June 30, 2017

Ms. Helen Donaldson
City of Portland Planning Authority
4th Floor, City Hall
389 Congress Street
Portland, ME 04101

**RE: AC Hotel Portland
Plan Set Revision Summary**

Plan Set Sheet Revision / Update Summary

Sheet No. L2.0
Sheet 15 of 20

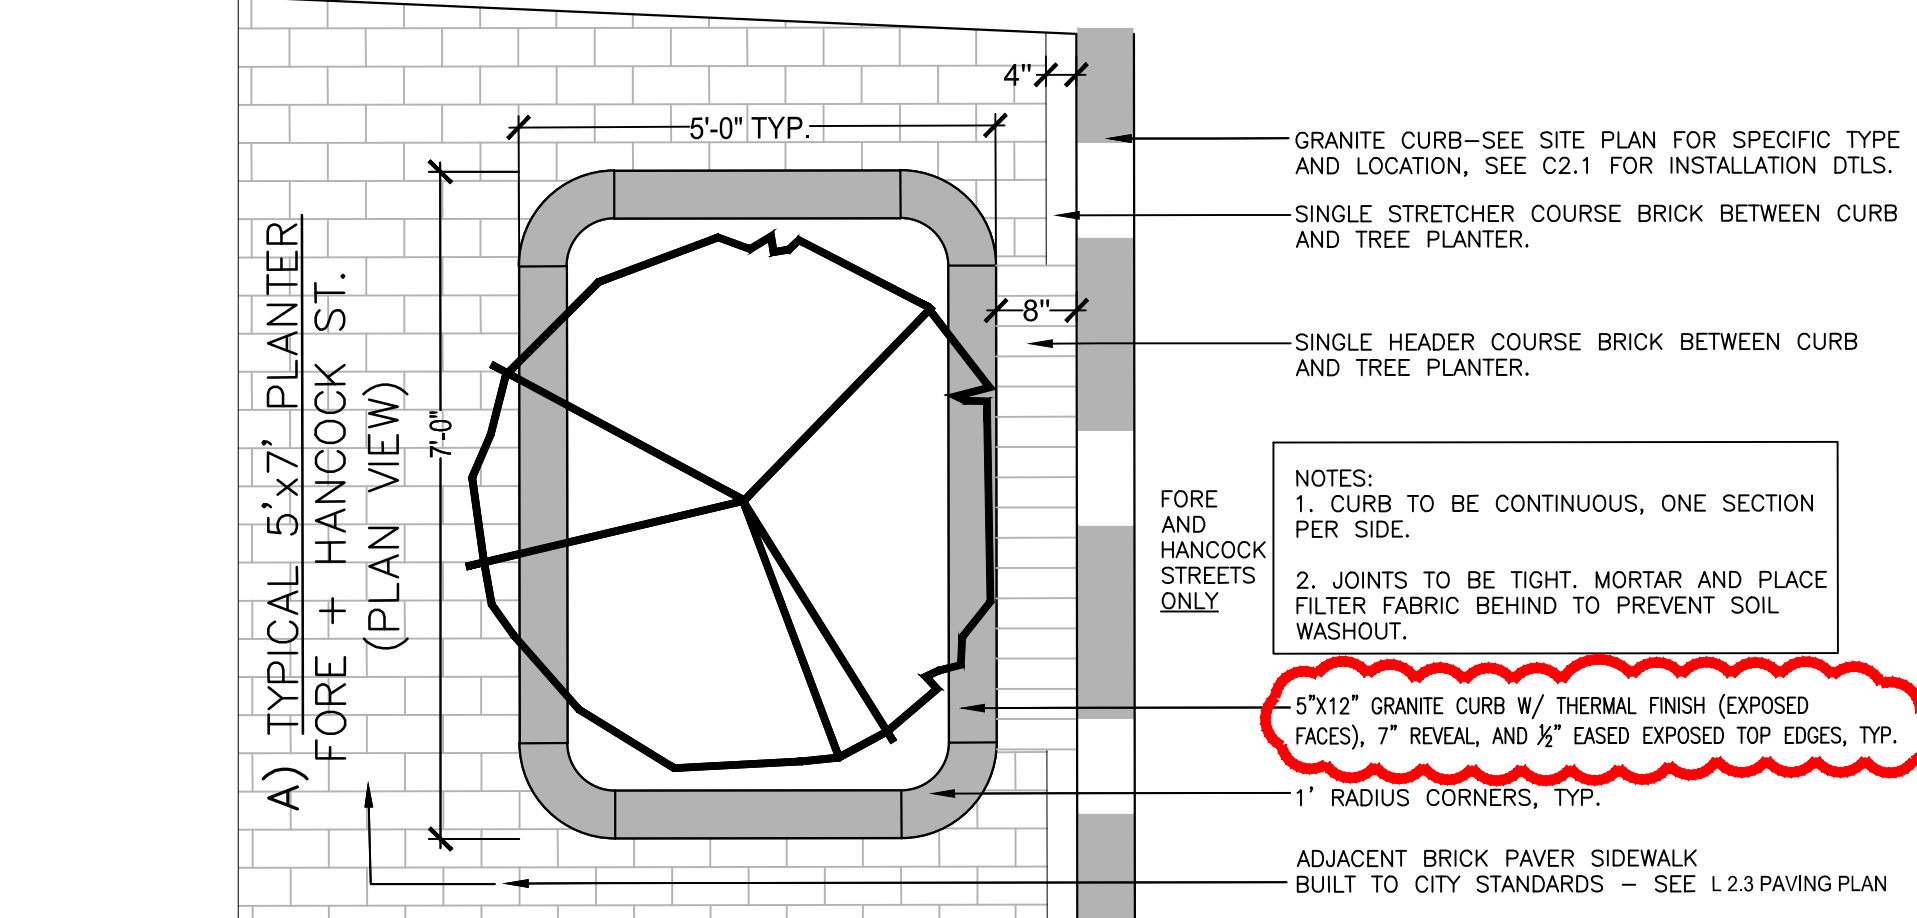
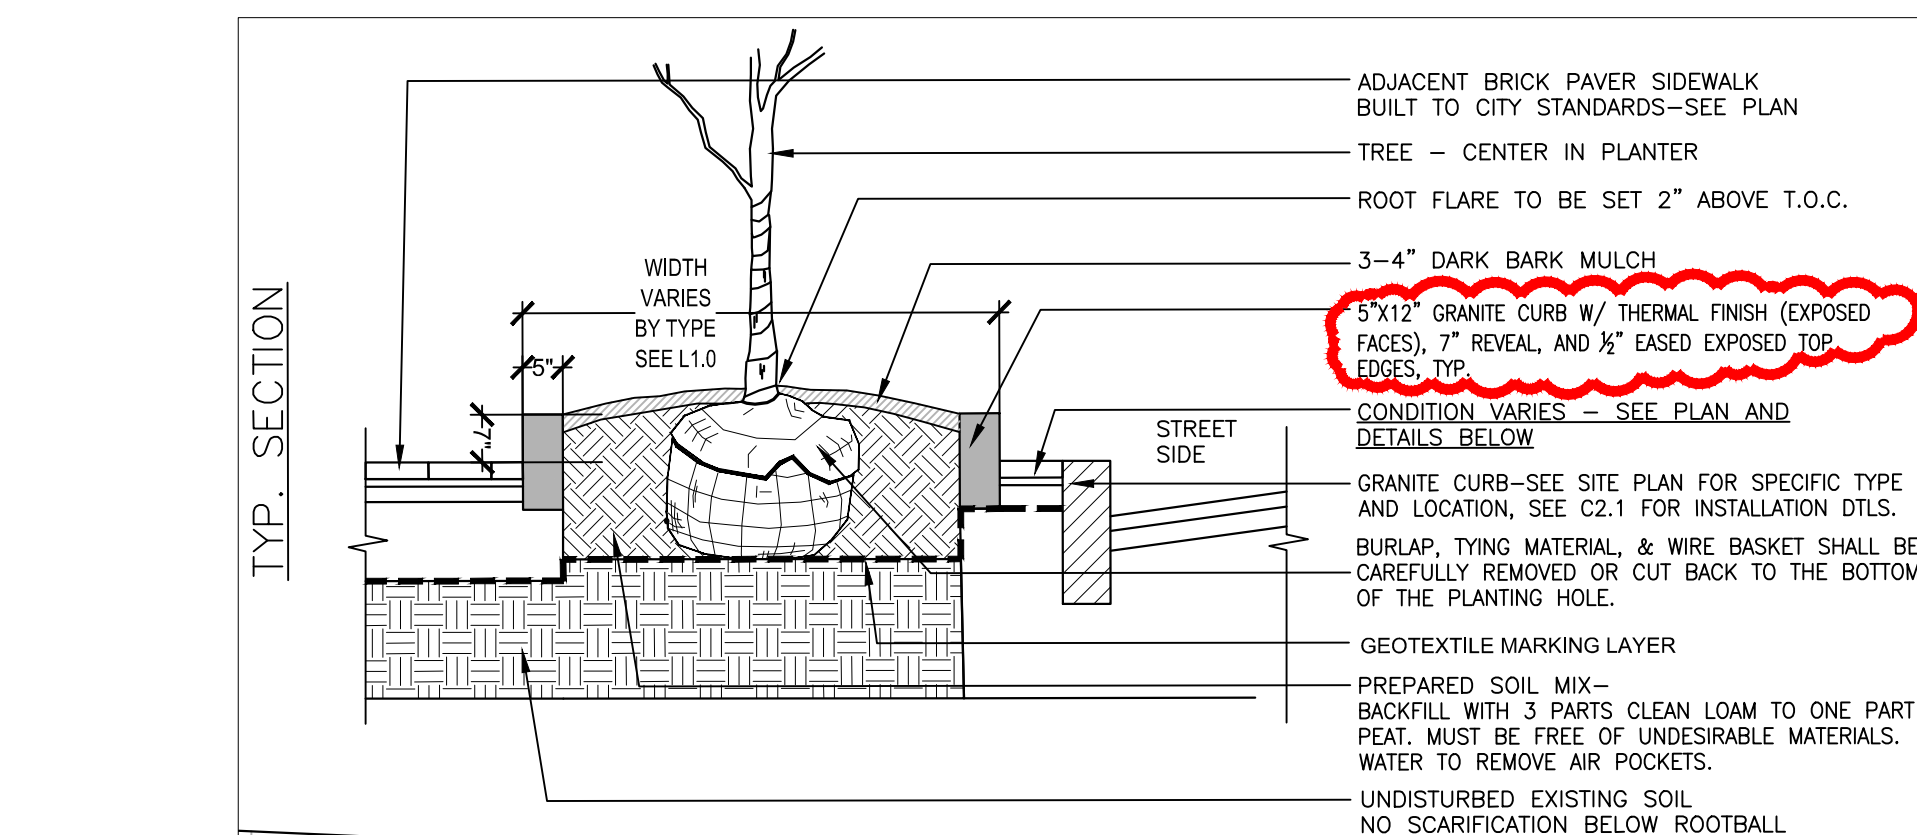
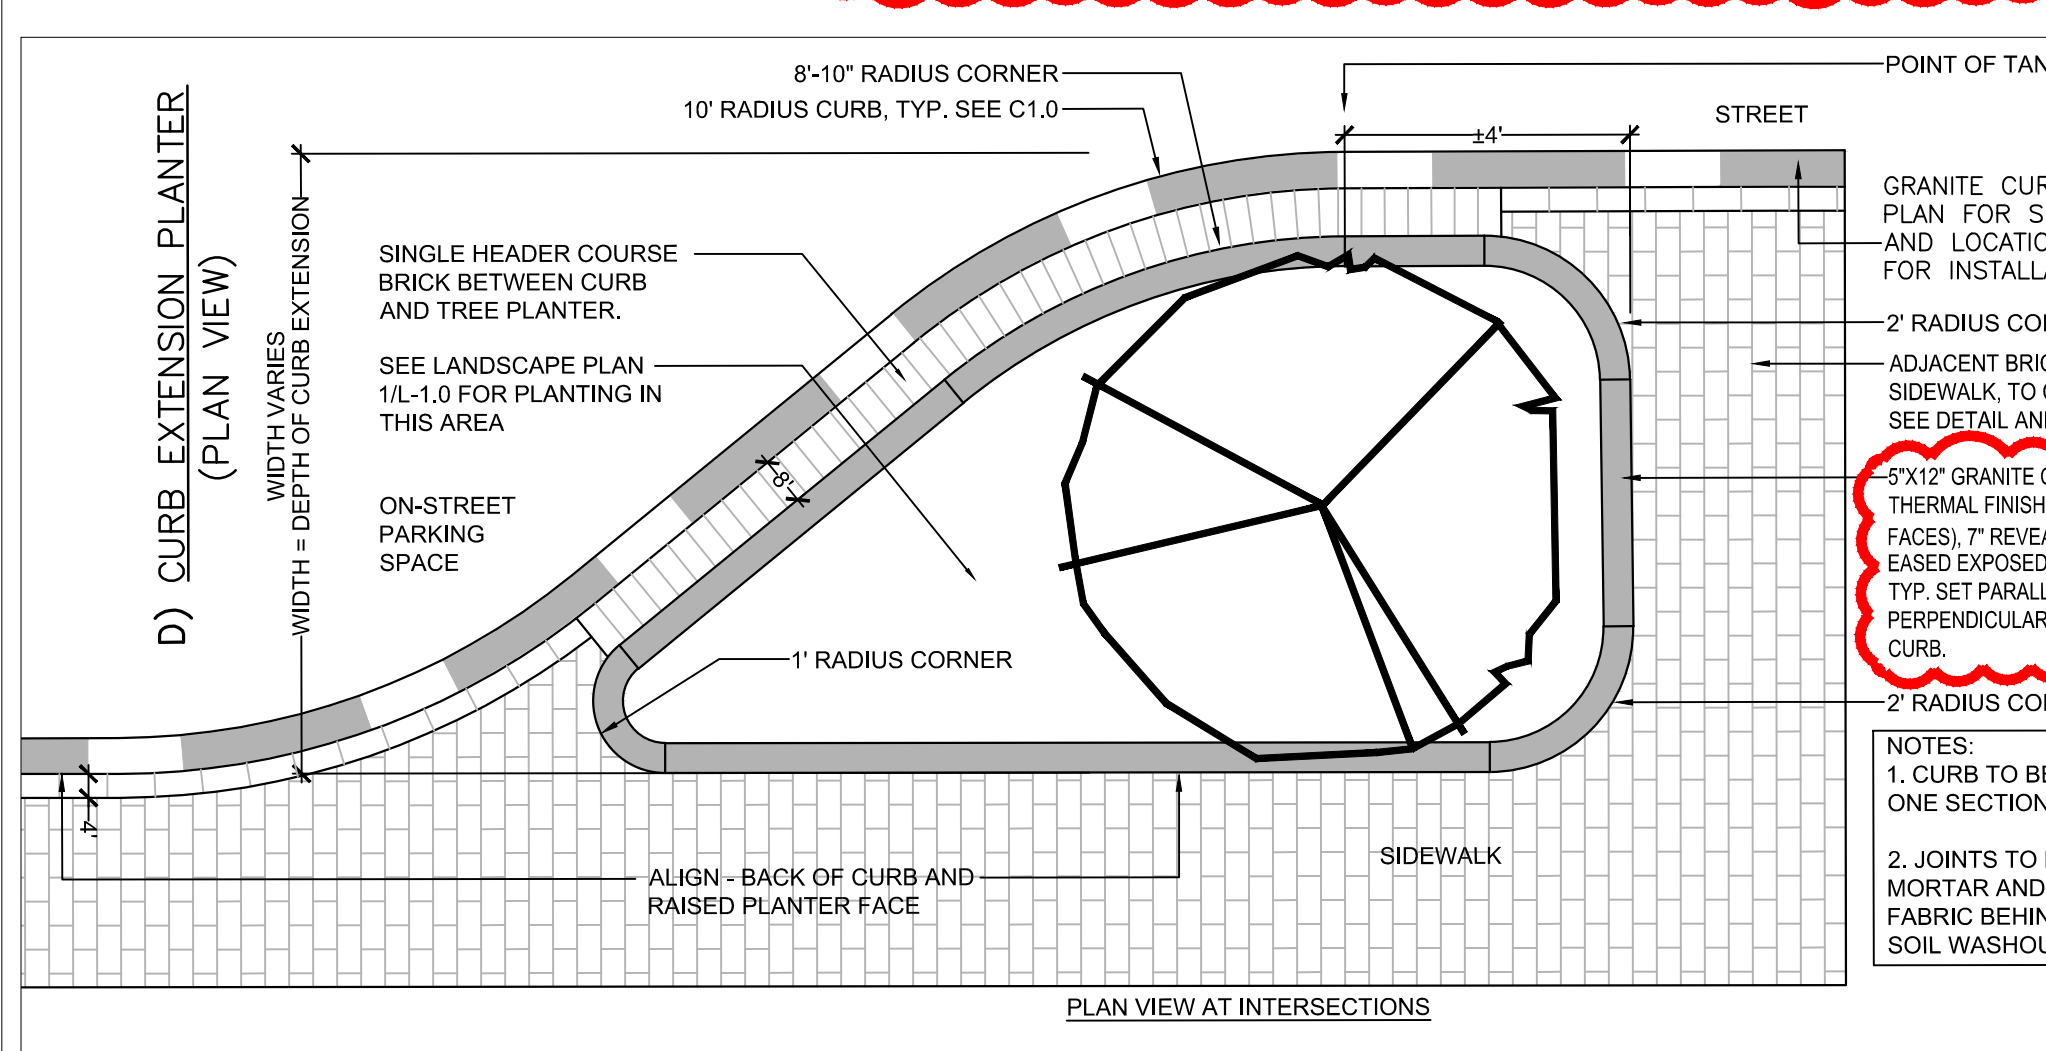
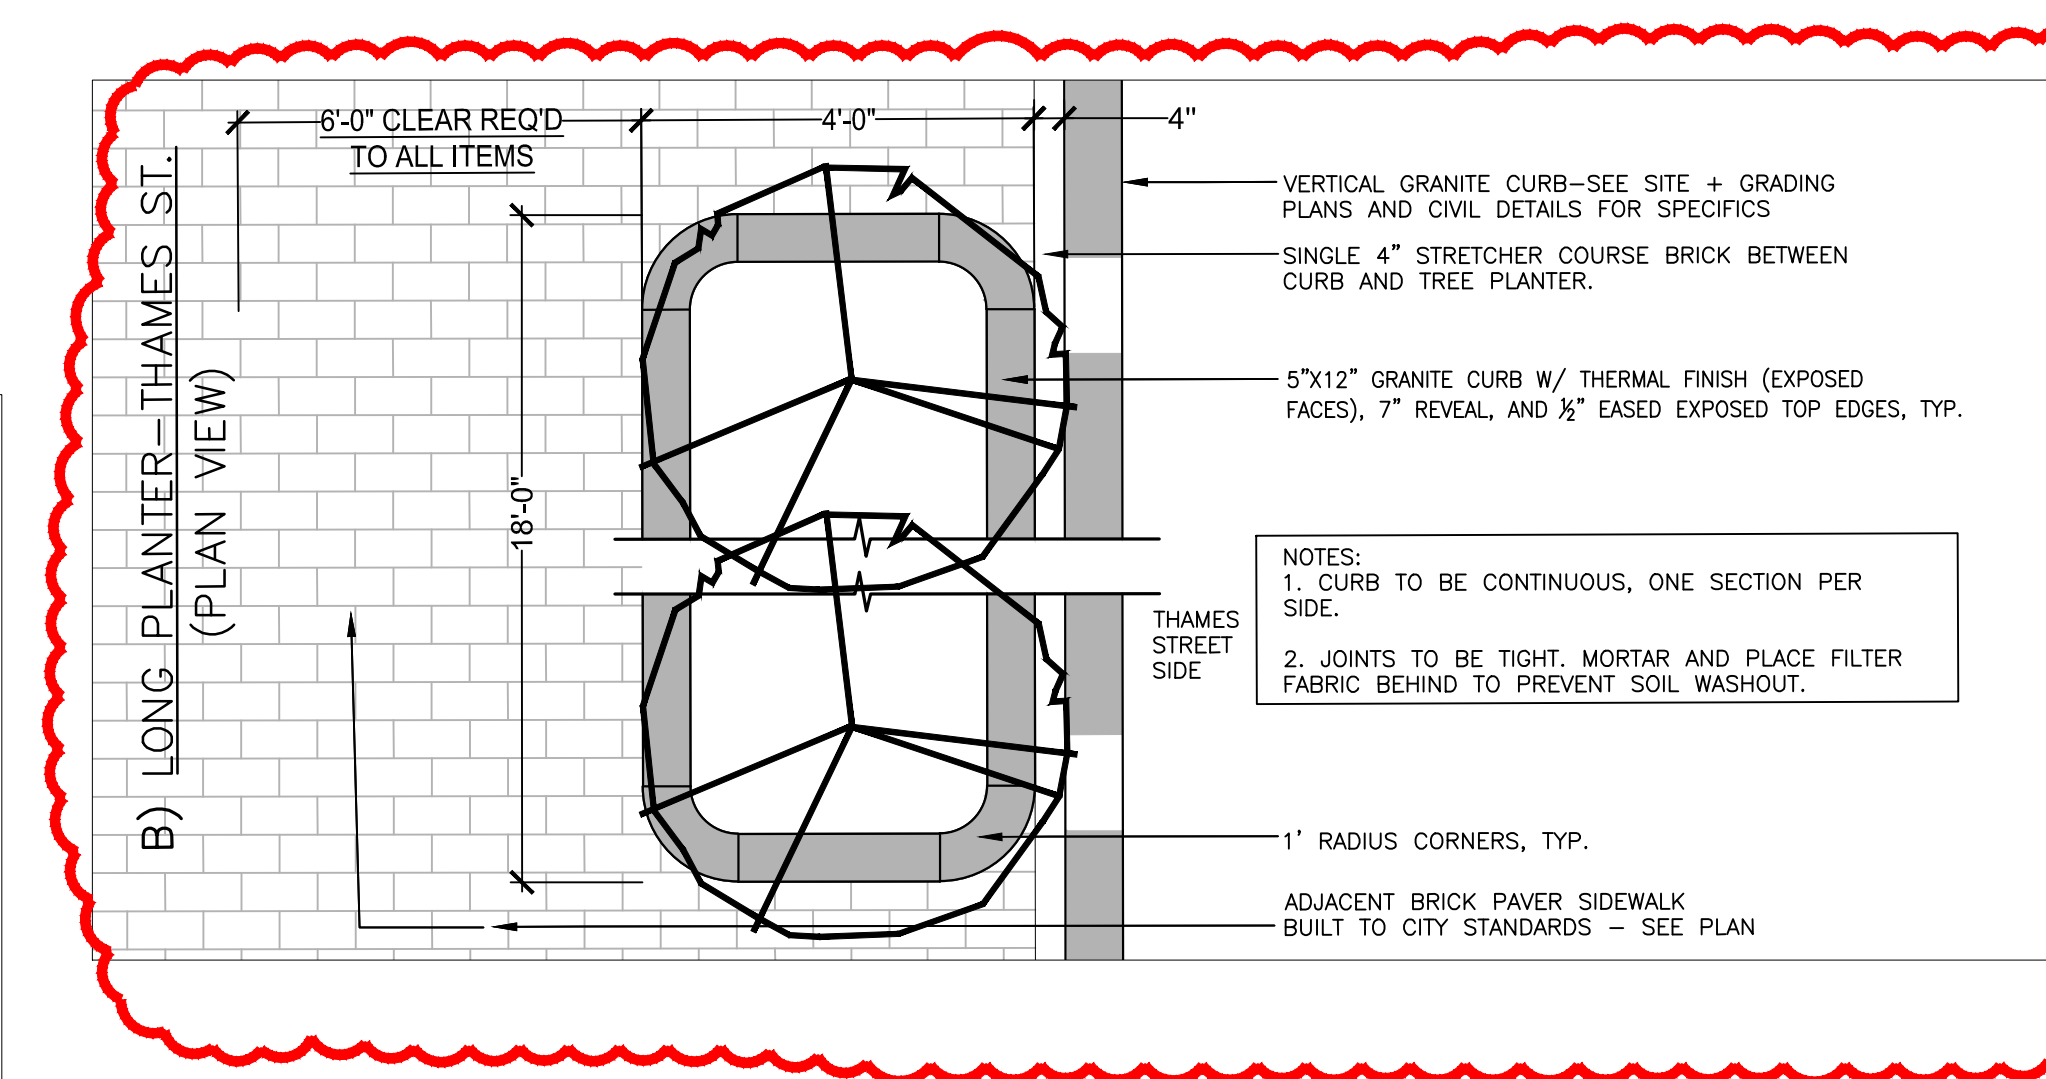
Revisions: Update granite finish info for tree planters and edging. Remove narrow and three sided tree planters (as no longer used along Thames St.) and add long planter.

Design by:	MPM	Checked by:	SJB
Drawn by:	JAR	Approved by:	SJB
Project:	150.06094	Date:	AUGUST 2015
Sheet No:	C1.0		
	Sheet 4 of 17

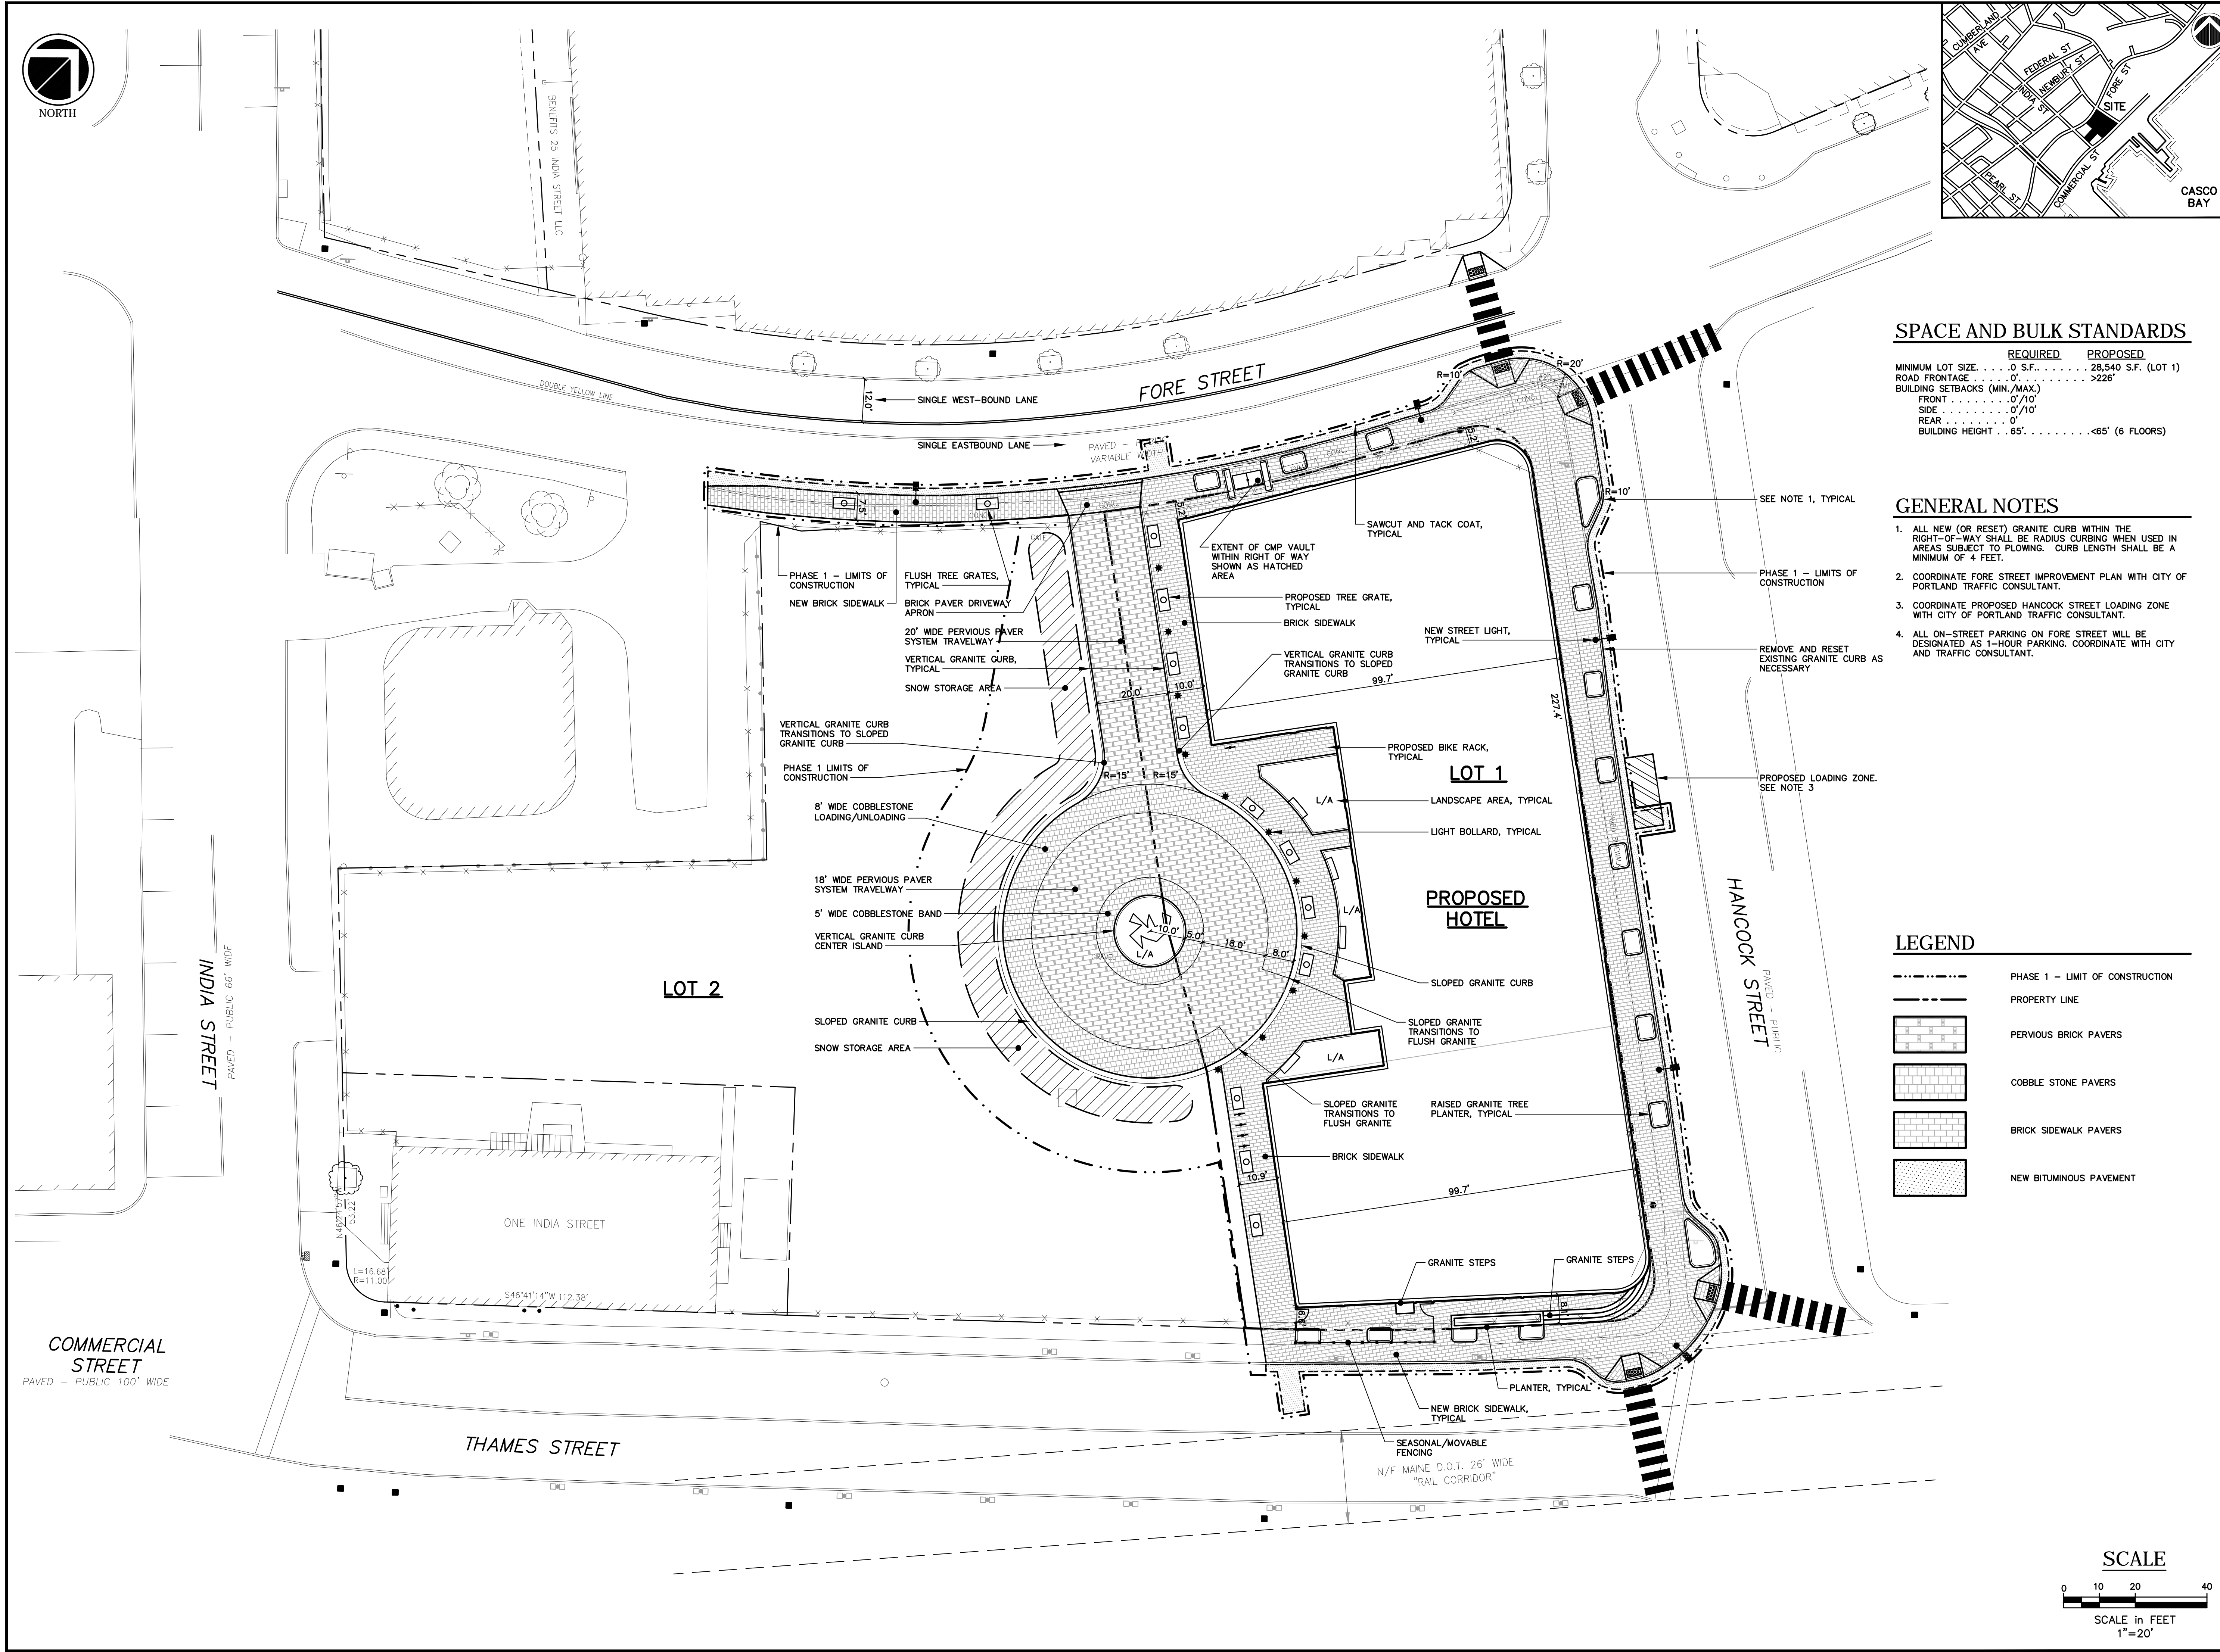
Revisions: Relocate all bike racks (5) to one central location adjacent to the drop-off circle, reduce size of adjacent landscape bed, remove streetscape improvements along Fore Street south of entry driveway from hotel project; revisions to stairs/outdoor seating at Thames Street entrance (see sheet L1.1).
